**Appendix K to the Relevant Representations of Natural England
Landscape and Visual Impact Assessment**

The construction and operation of the Five Estuaries Offshore Wind Farm located approximately 57km from the Essex Coast in the Southern North Sea.

Planning Inspectorate Reference EN010115

13 August 2024

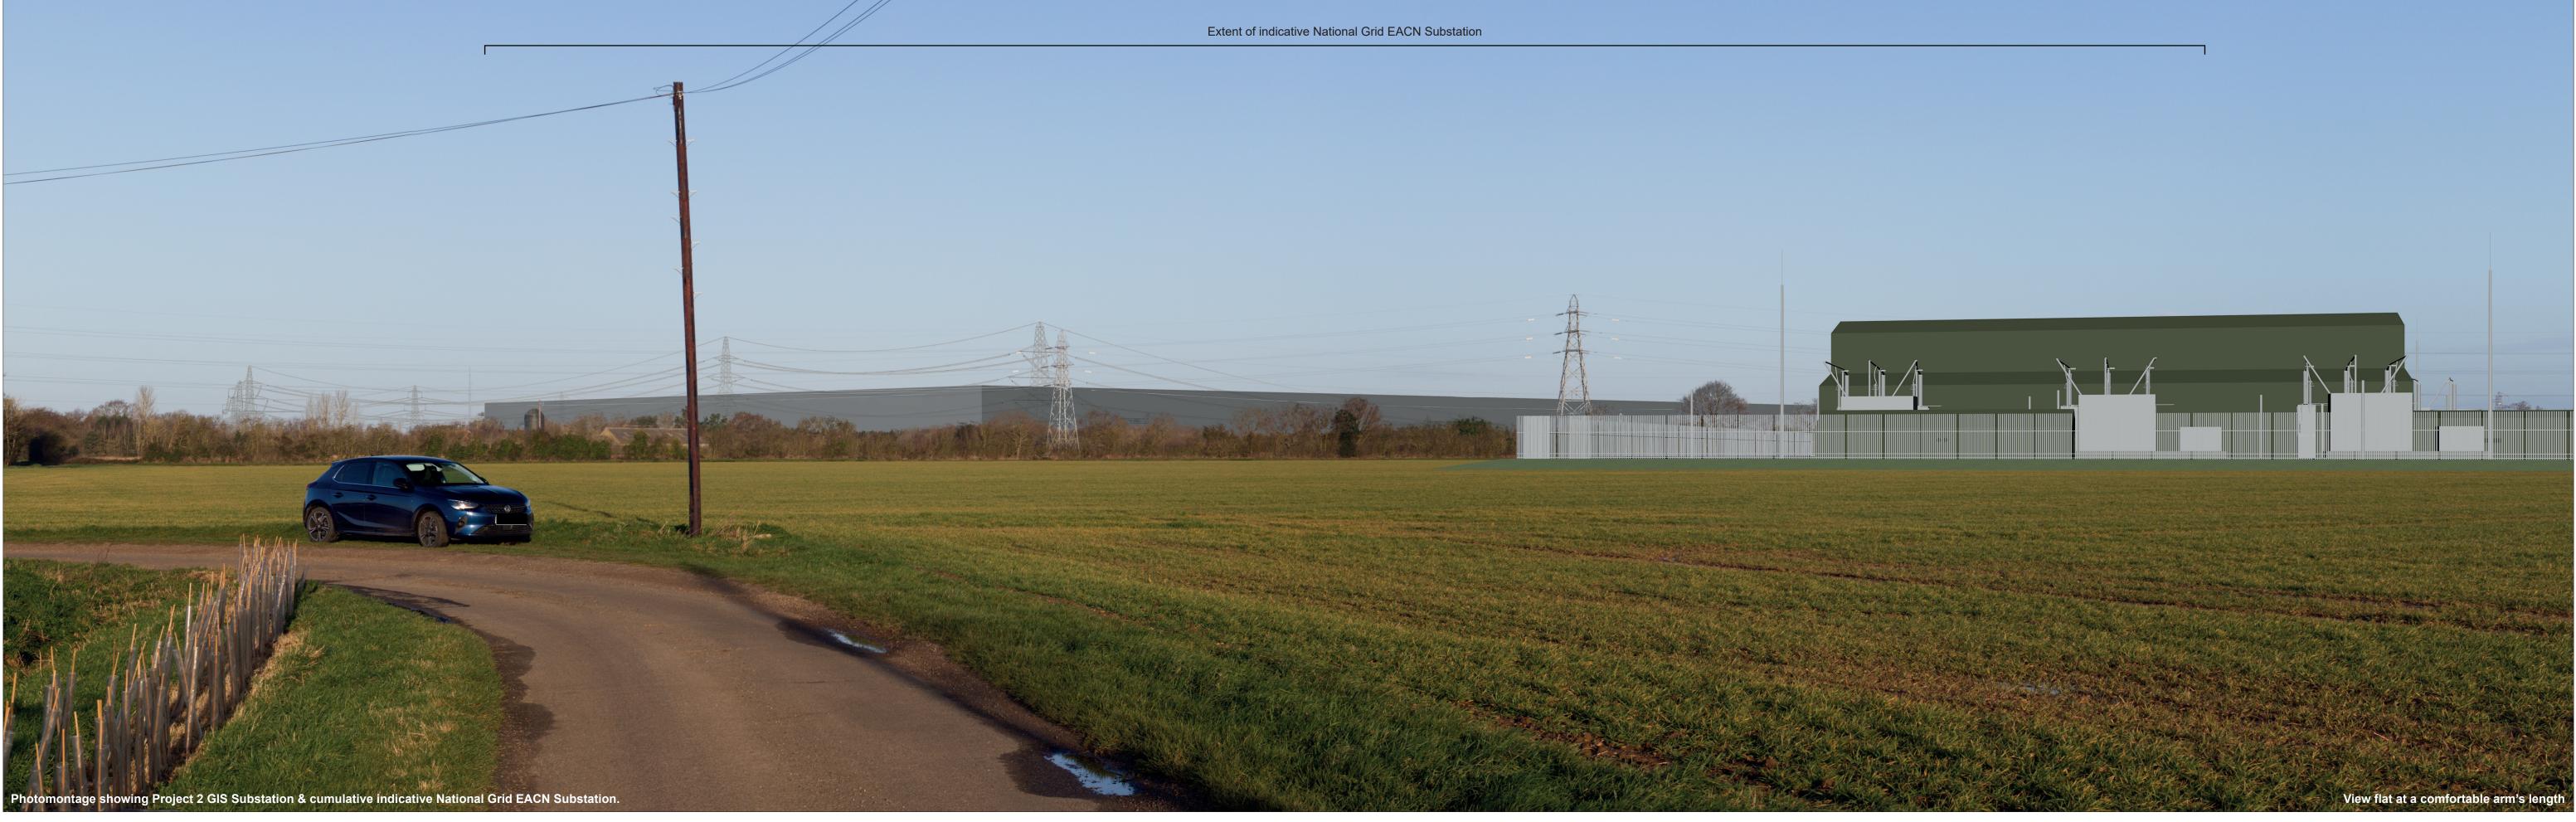
K5	P113 VP11 Annex 2.2.16: Figure	Natural England notes that Bounds Farm V11 is approximately 1km south of the Dedham Vale National Landscape boundary. While we agree that there is unlikely to be a change to the baseline view and therefore no effect on visual	Natural England advise that the Applicant considers additional mitigation measures which may address the winter visibility whilst mitigation screening is established.

Natural England's Key Considerations	Natural England's Advice				
Relevant and Written Representations	NE Ref	Ref	Comment	Recommendation.	Risk (RAG)
		2.26a-c VP11 Bounds Farm Hungerd own Lane	receptors for at Bounds Farm, for both VE alone and VE delivered alongside the North Falls substation; there it is a possibility that there may be some visibility in winter at year 0 before mitigation screening is established.		
	K6	Sec 2.6	<p>Natural England advises that the above two visualisations, along with the screened Zone of Theoretical Visibility (ZTV) and conclusions within the LVIA provide reassurance that the proposed VE substation, both as a standalone project, and in combination with the North Falls substation, will not be visible from Dedham Vale or Suffolk and Essex Coasts and Heaths National Landscape. Therefore, we agree with the Applicant that there is unlikely to be any significant adverse landscape and visual effects arising to either National Landscape because of the terrestrial aspects of the project.</p> <p>Therefore, Natural England will not provide further comment on NLs during the examination.</p>	N/A
